Engineers Comments Regarding Surface Water Drainage

Application Reference:	WA/106/24/DOC	Reviewer Reference:	ADC/EXT2/D2134/68
Planning Officer:	Kathryn Welch	Date of Review:	13.11.2025
Site Name:	Land East of Tye Lane Walberton		
Application Description:	Approval of details reserved by condition imposed under reference WA/124/23/S73 relating to condition number 23(b) - SuDS System , and condition number 25(b) - SuDS Maintenance Manual.		
Assessment Number:	2 Of 2

Application Reference: WA/106/24/DOC Site Name: Land East of Tye Lane Walberton	Initial Issue Date: 13/11/2025 Issue Date: 13/11/2025 Reviewer Reference: ADC/EXT2/D2134/68
--	---

Swale O-N - 9 July 2024 - complete and functioning

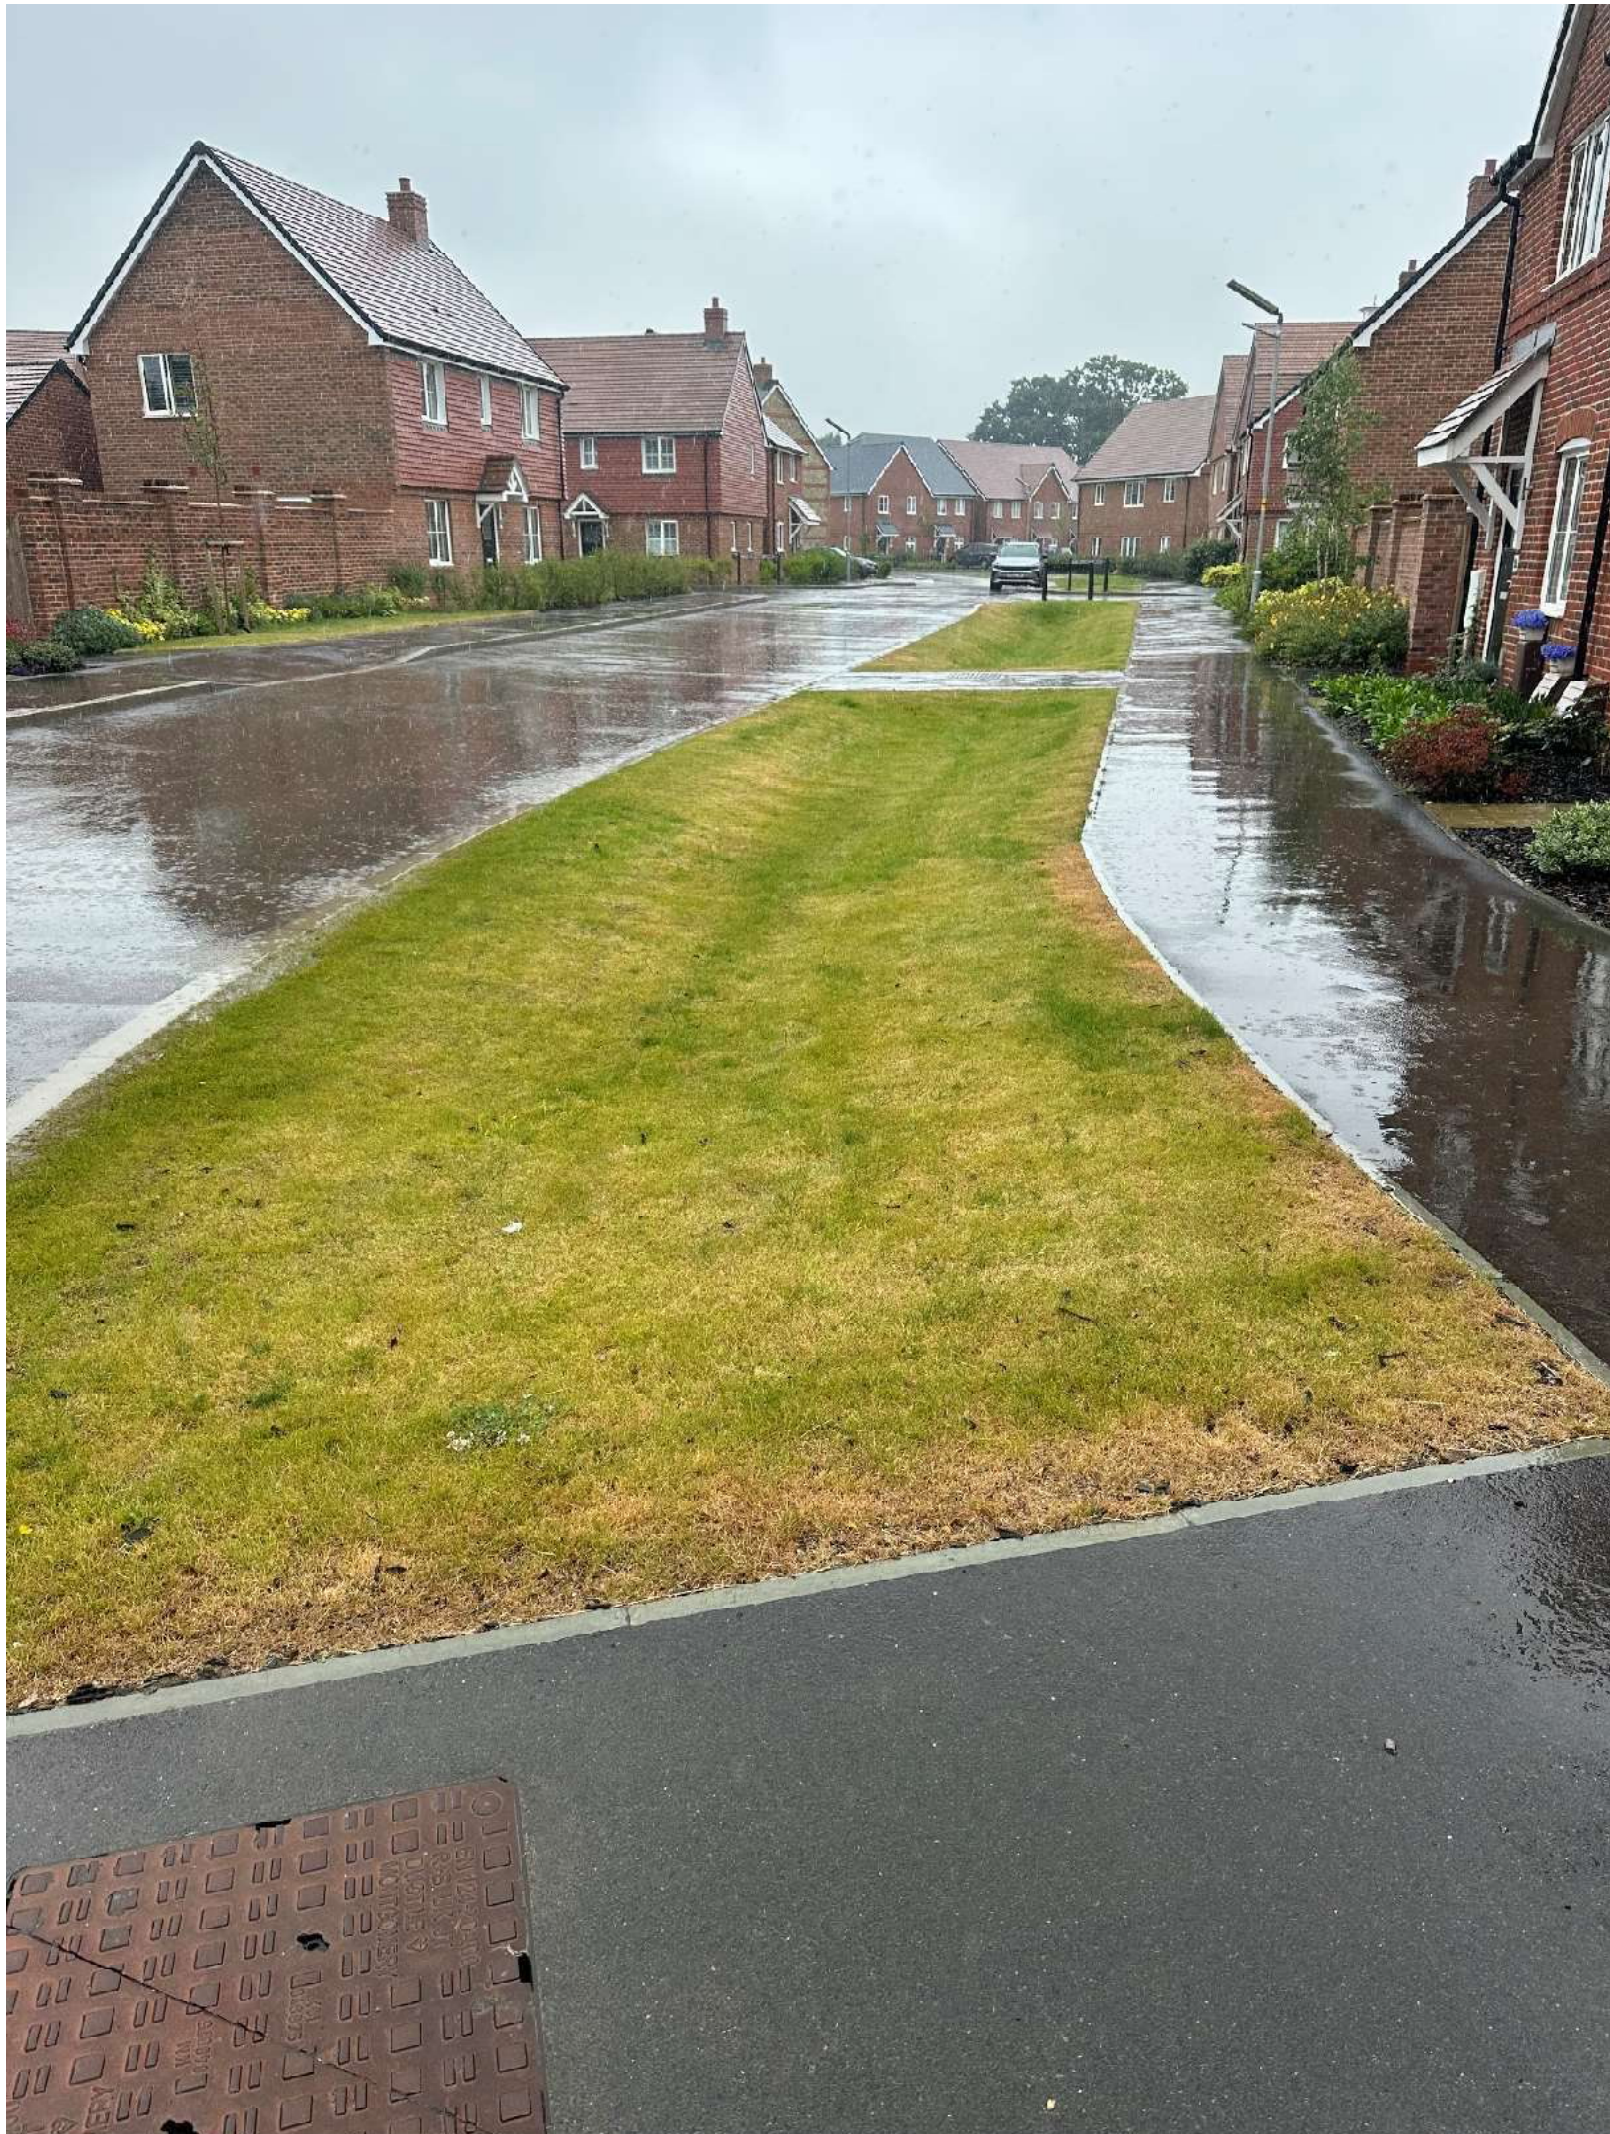
be provided to verify depths, etc. ADC Drainage Comments 24/02/2025 [WA/106/24/DOC] Comment outstanding. Designer Comments 1/04/2025 [WA/106/24/DOC] As per appendix F				
	ADC Drainage Comments 03.08.2023 [WA/17/23/DOC – Full Site] As constructed floor levels should also be verified/considered to ensure no increase in flood risk. ADC Drainage Comments 24/02/2025 [WA/106/24/DOC] Comment outstanding. Designer Comments 1/04/2025 [WA/106/24/DOC] As per appendix F	Noted. Comment closed.			
	ADC Drainage Comments 03.08.2023 [WA/17/23/DOC – Full Site] Page 24 photo evidence shows swale K/L to be incomplete.	Noted. Comment closed.
